DRB Application No.: <u>06DRB-01505 (P&F)</u>	Project # <u>1005169</u>
Project Name <u>UNM AIRPORT PARCEL</u>	
Agent: <u>Alpha Professional Surveying</u>	Phone No.: <u>892-1076</u>

2. Project # 1005169
06DRB-01504 Major-Bulk Land Variance
06DRB-01505 Minor-Prelim&Final Plat Approval

ALPHA PROFESSIONAL SURVEYING agent(s) for UNM REAL ESTATE DEPARTMENT request(s) the above action(s) for all or a portion of Tract(s) 10 & 11, **UNIVERSITY OF NEW MEXICO, AIRPORT PARCEL**, zoned M-2 located on IRA SPRECHER RD SE, between LOS PICAROS SE and the ALBUQUERQUE SUNPORT SE, containing approximately 446 acre(s). (P-16/P-17)

DEVELOPMENT REVIEW BOARD – SPEED MEMO

**BULK LAND PLAT OF
TRACTS 1 & 2
UNIVERSITY OF NEW MEXICO
"AIRPORT PARCEL"
IN SECTIONS 10 & 11, T. 9 N., R. 3 E., N.M.P.M.**

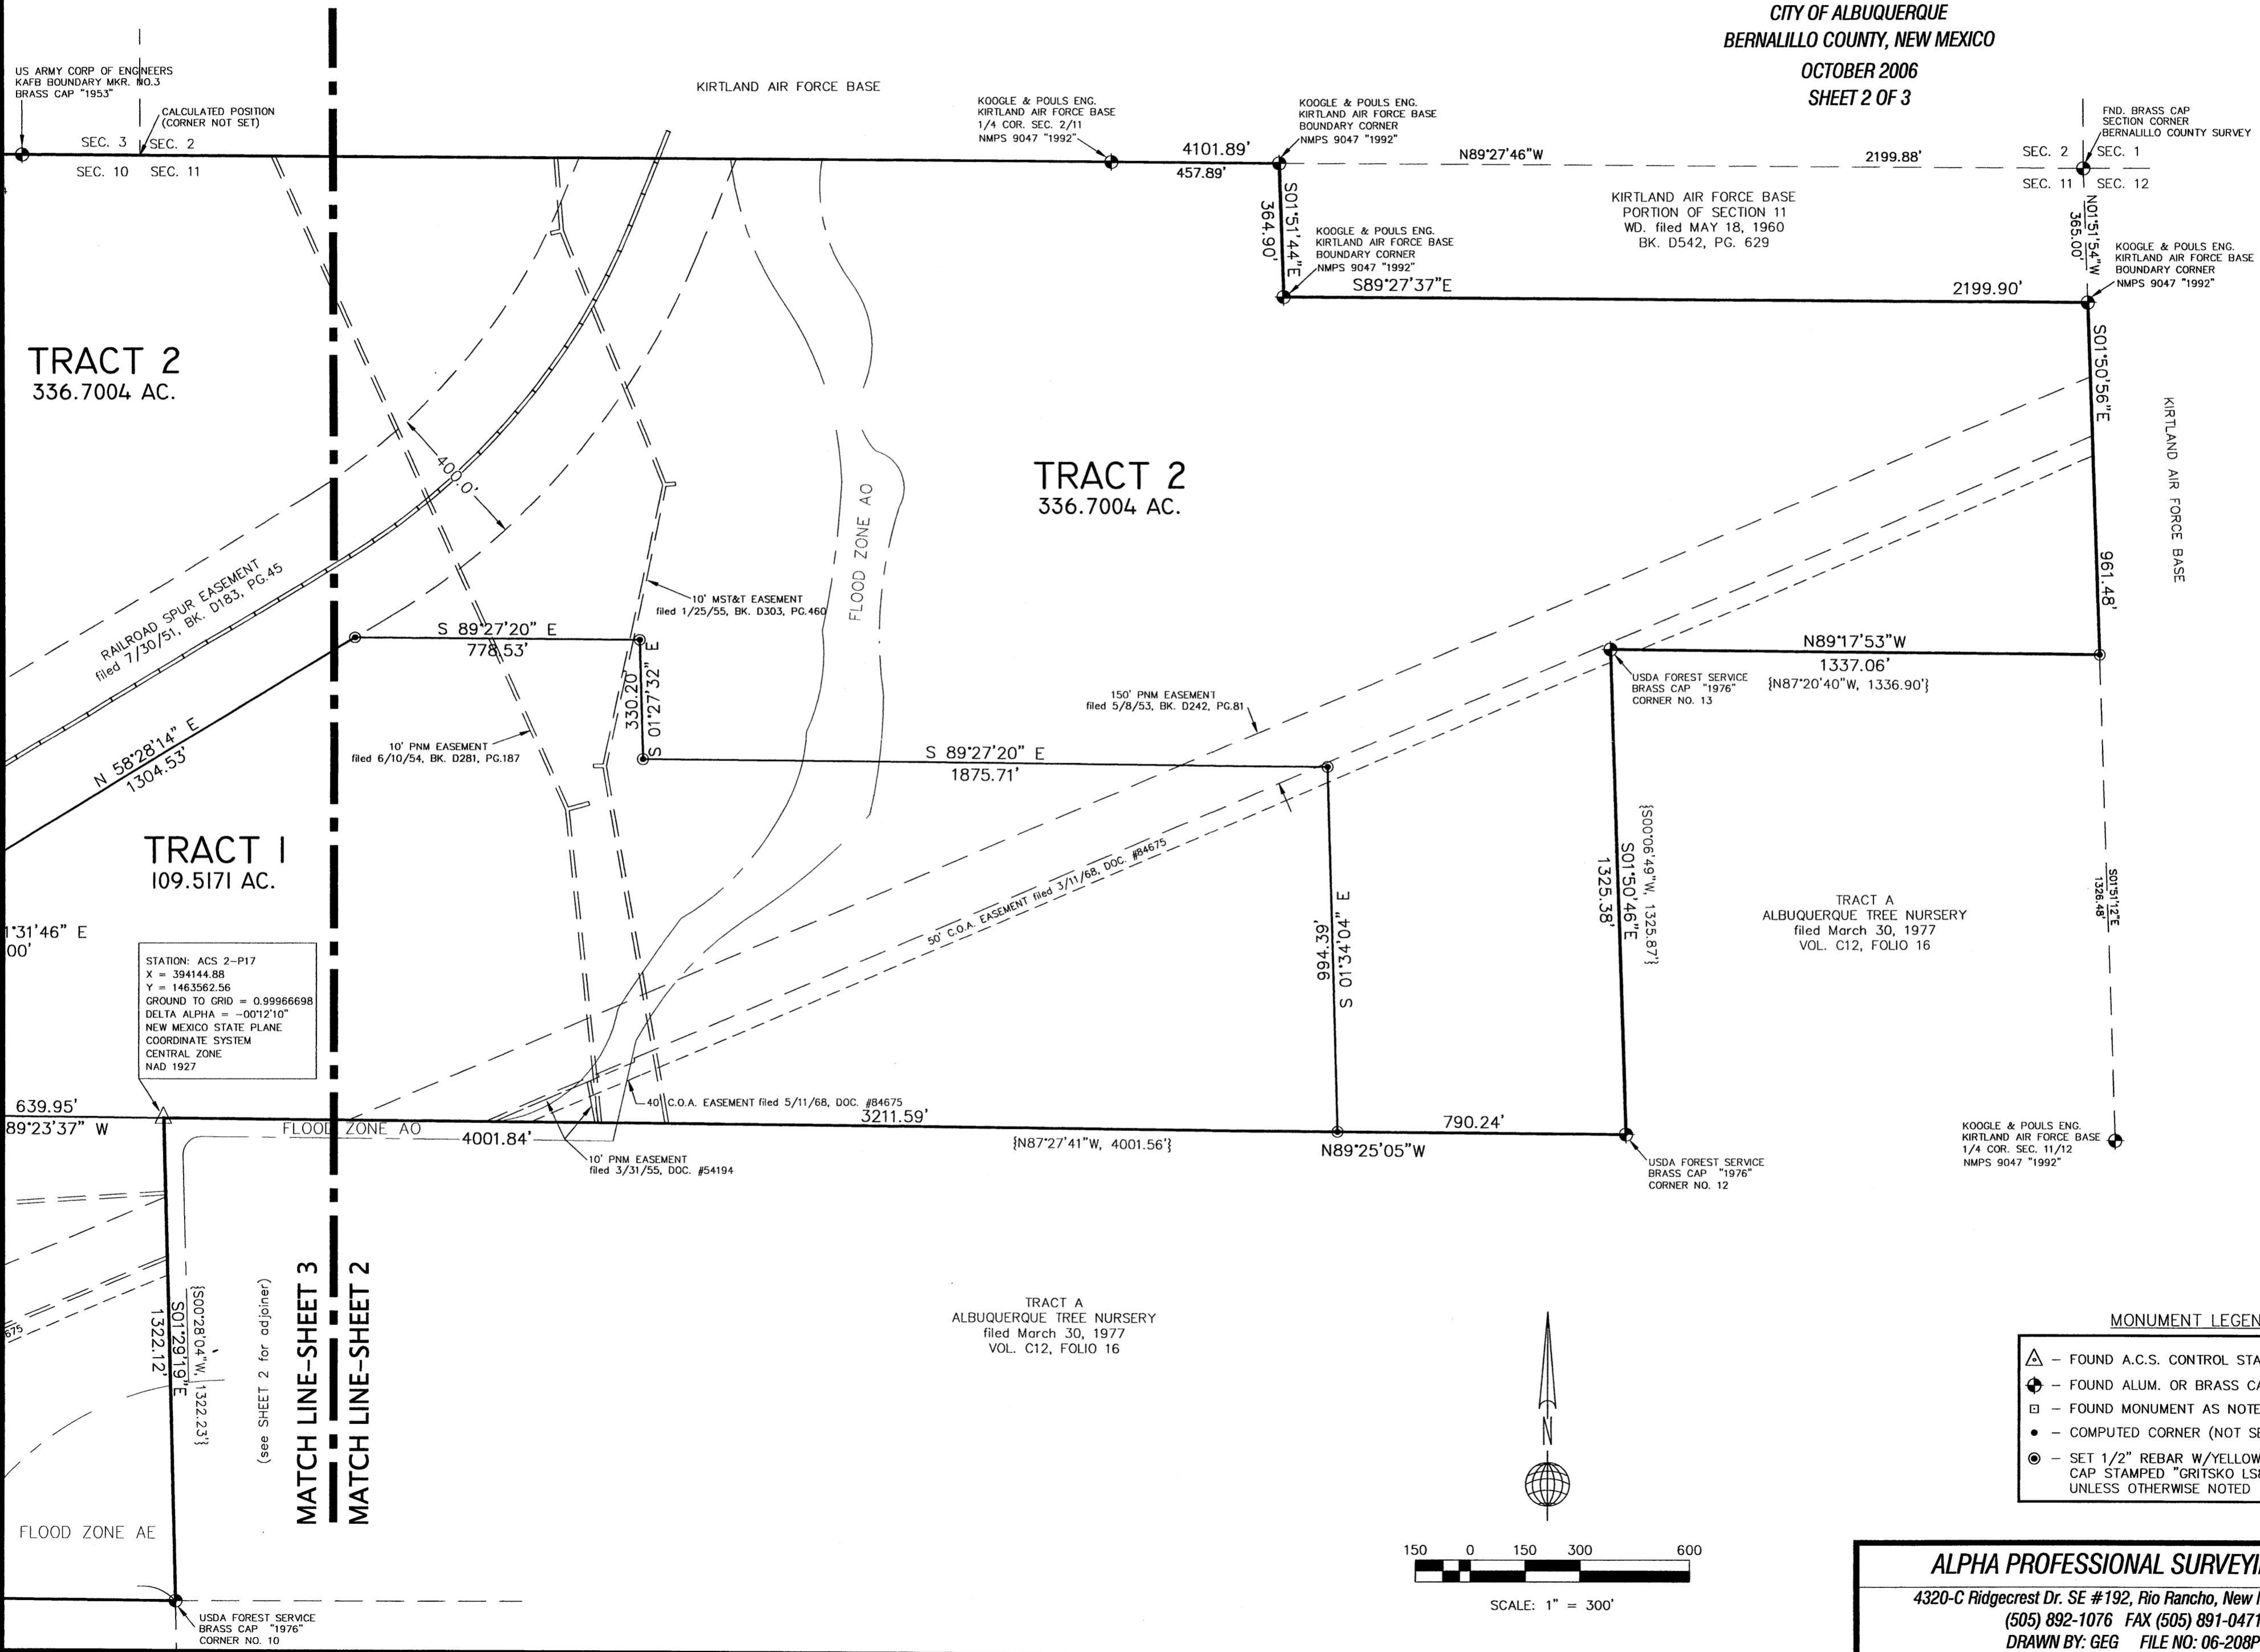
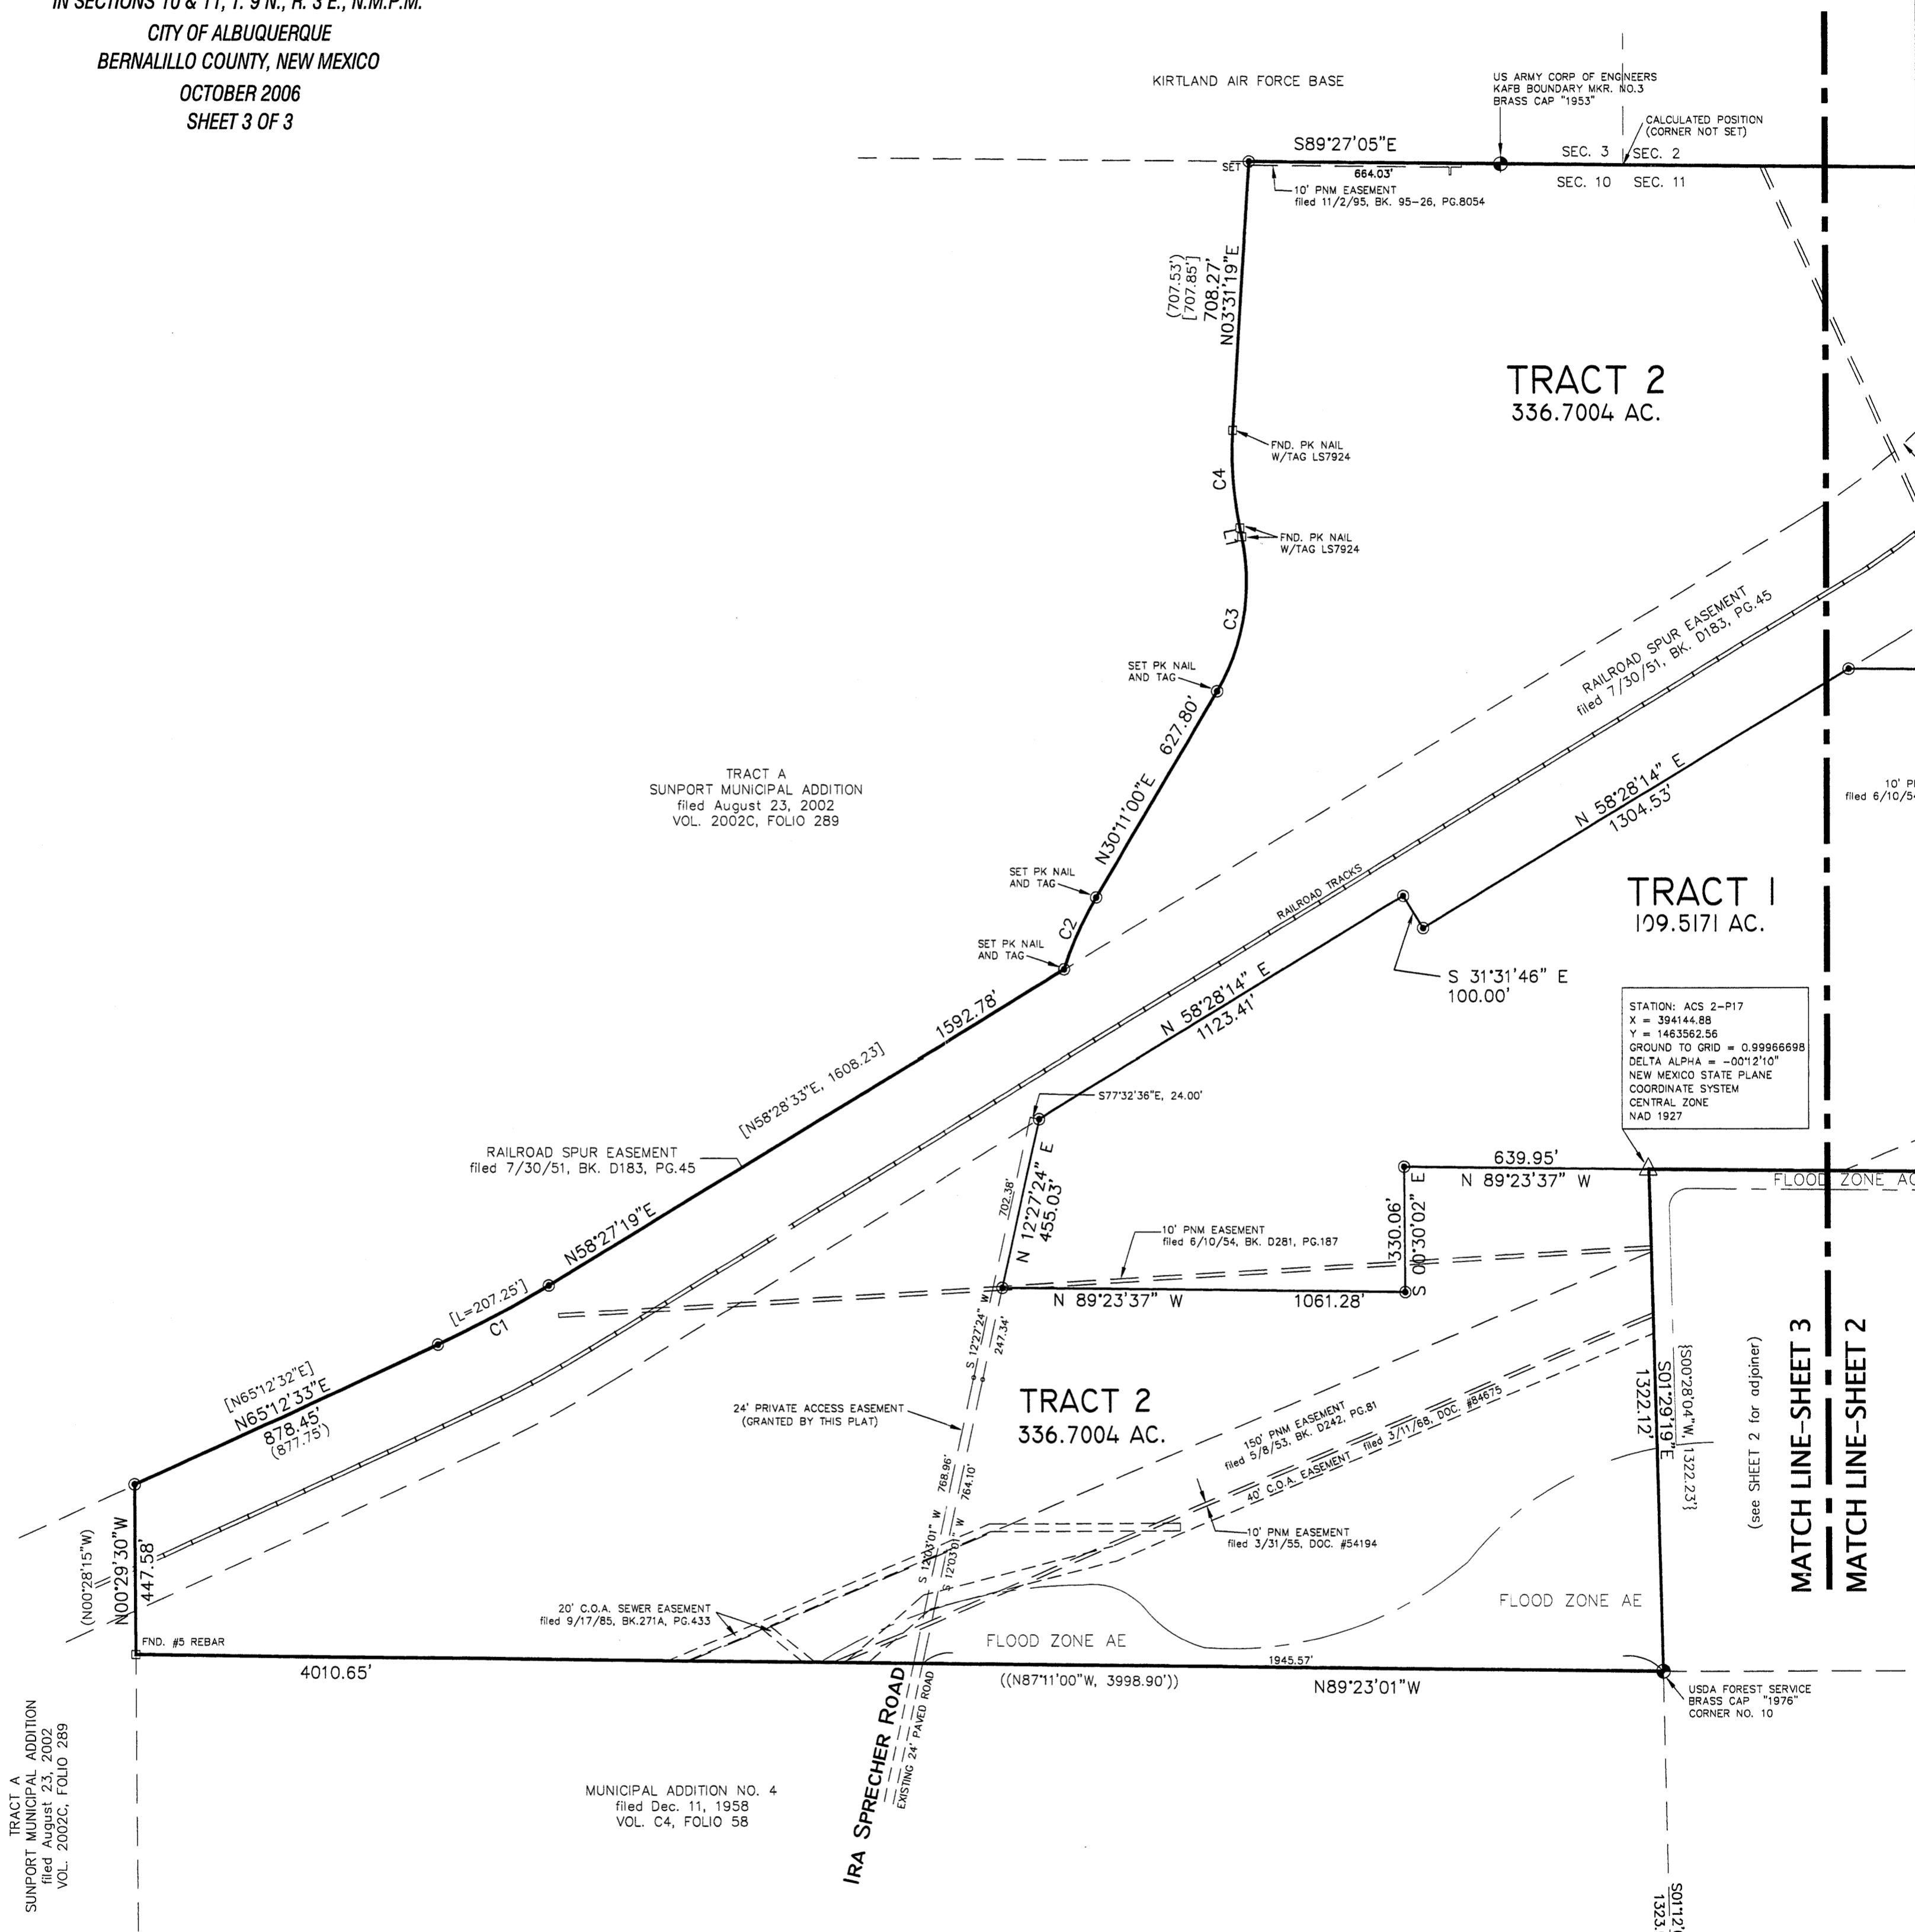
No objection to Bulk Land Variance.
Need floodplain easement(s) granted to the City of Albuquerque.

Where is the documentation for Ira Sprecher Road? How does this alignment fit with the Mesa del Sol master plan? No objection to the Bulk Land Variance.

1. The Subdivision Ordinance requires the owners of land being platted to warrant title to land being subdivided:

2. A separate sheet with the Notice of Subdivision Plat Conditions and the land owner and DRB Chair's signatures must also be recorded with the bulk plat. The Front Counter has the sheet.
